Application for a non-material amendment following a grant of planning permission. Town and Country Planning Act 1990

proposed alterations, removal of existing roof, new roof parrallel to Lanee,
tow storey extension, stone cladding to front and new porch. (Amended)

21/01642/HHD

psa - 04 rev F

psa ~ 04 revision 'G'

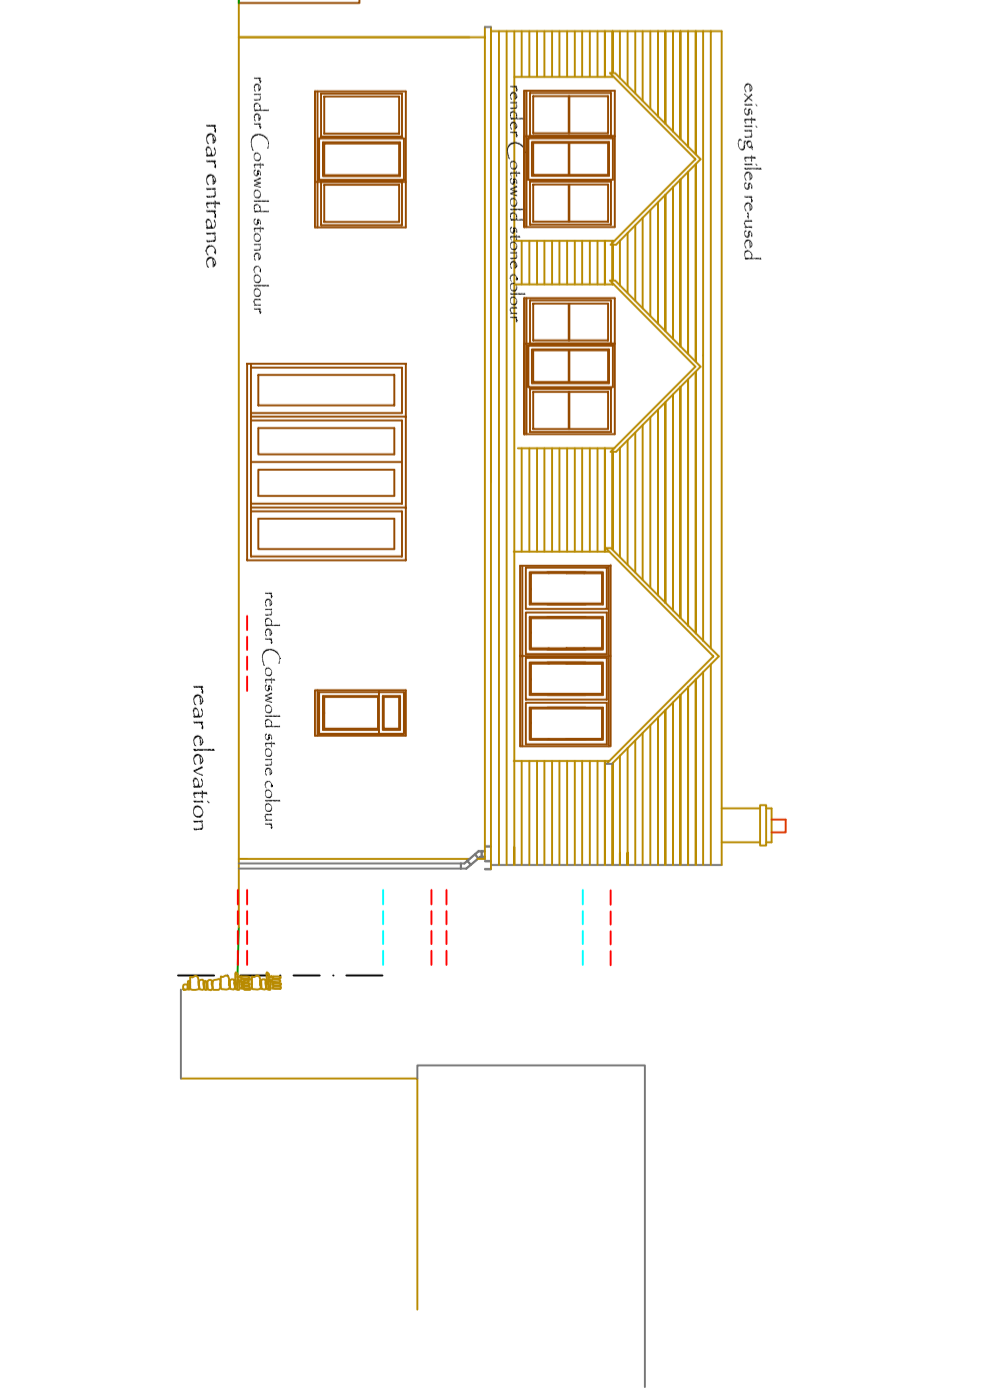
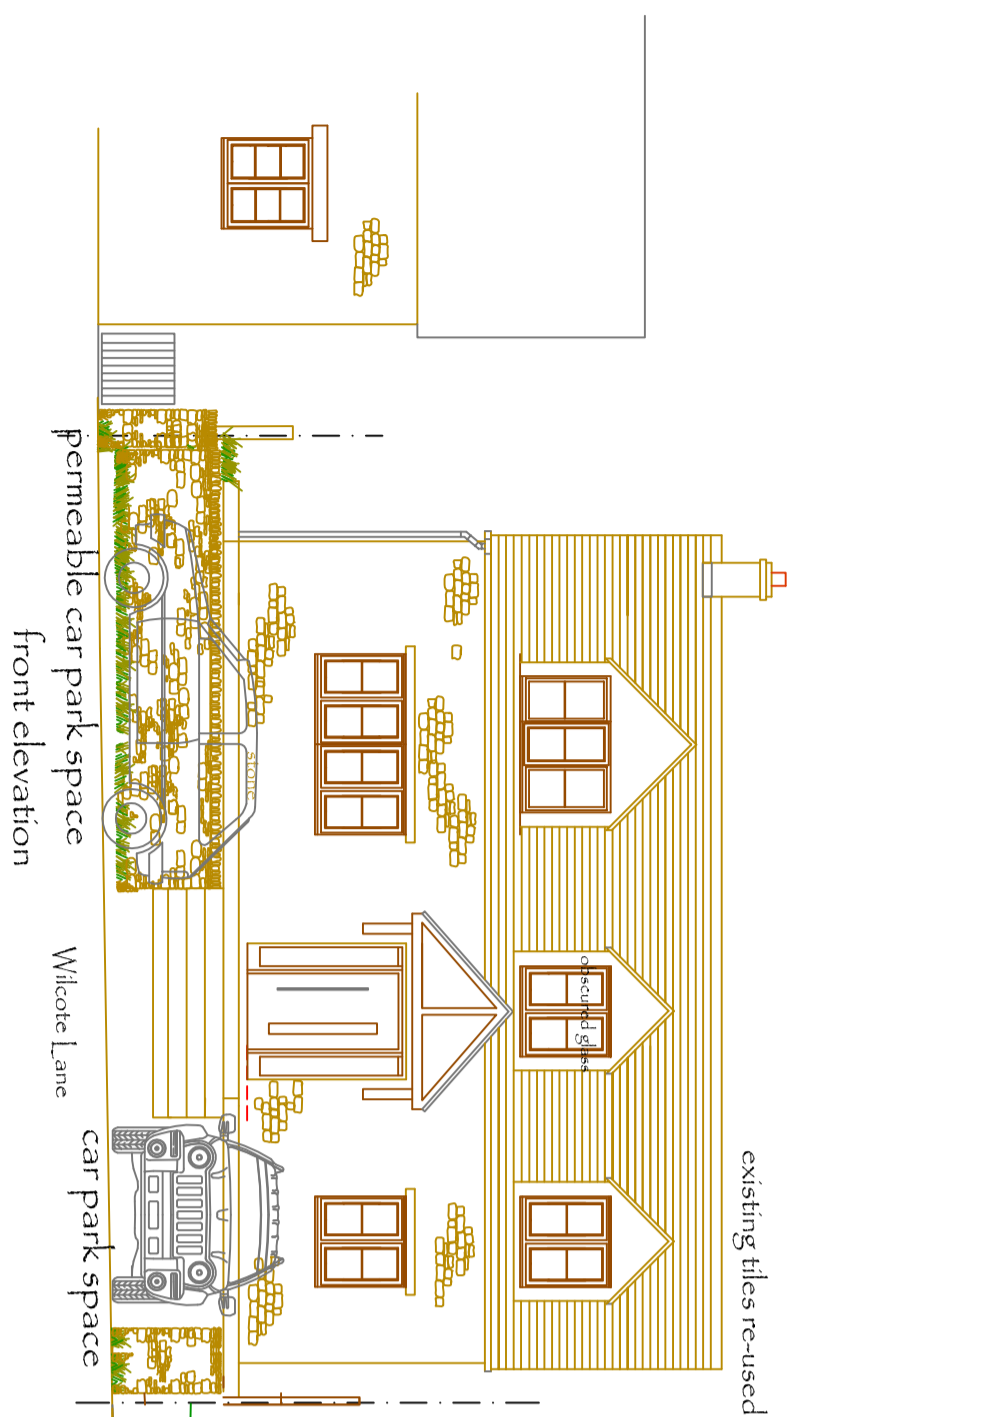
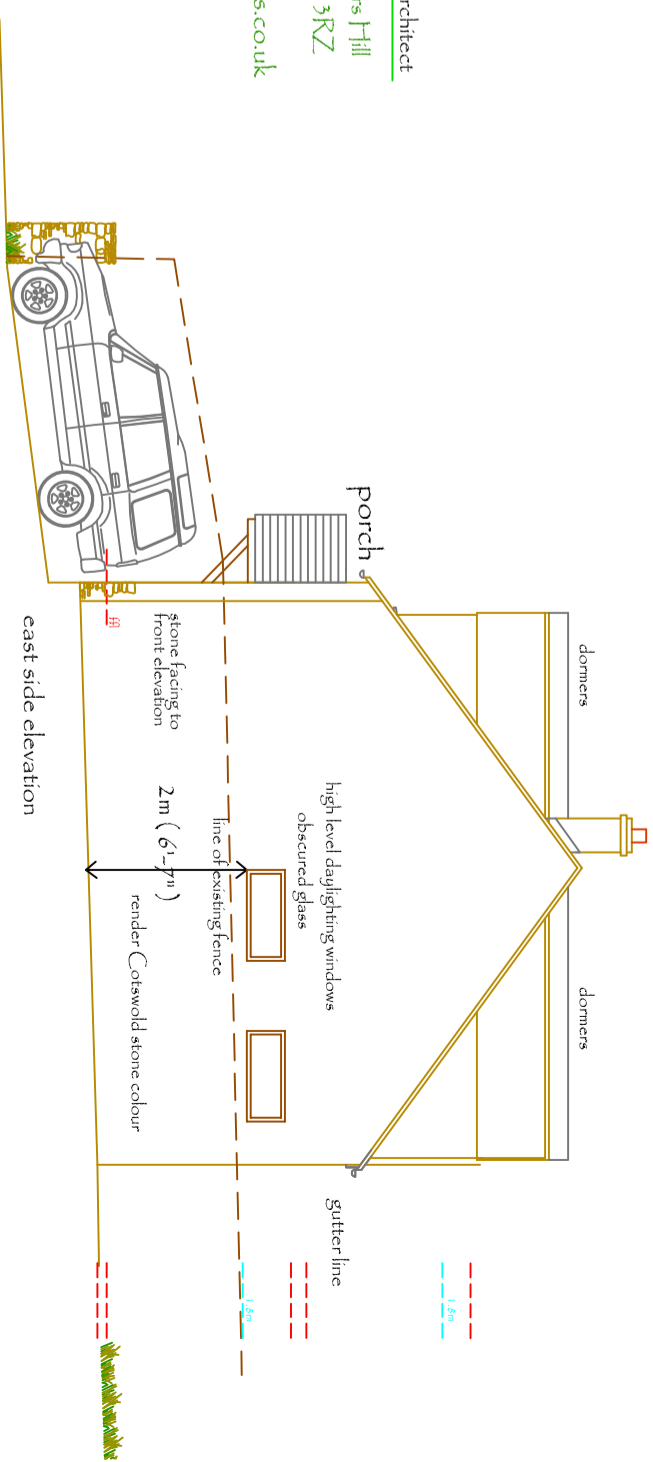
Re-location of two high level daylighting windows to east elevation towards the rear of the side elevation to light only the kitchen.

Adjustment of side elevation to show front dormers slightly further forward to allow dormers to be constructed to match front elevation approx 150 / 200mm - to be set out on site

Daylighting windows more effective to rear room - kitchen
Not required in front study room.

Technical adjustment of dormer outline to suit actual construction to match front elevation.
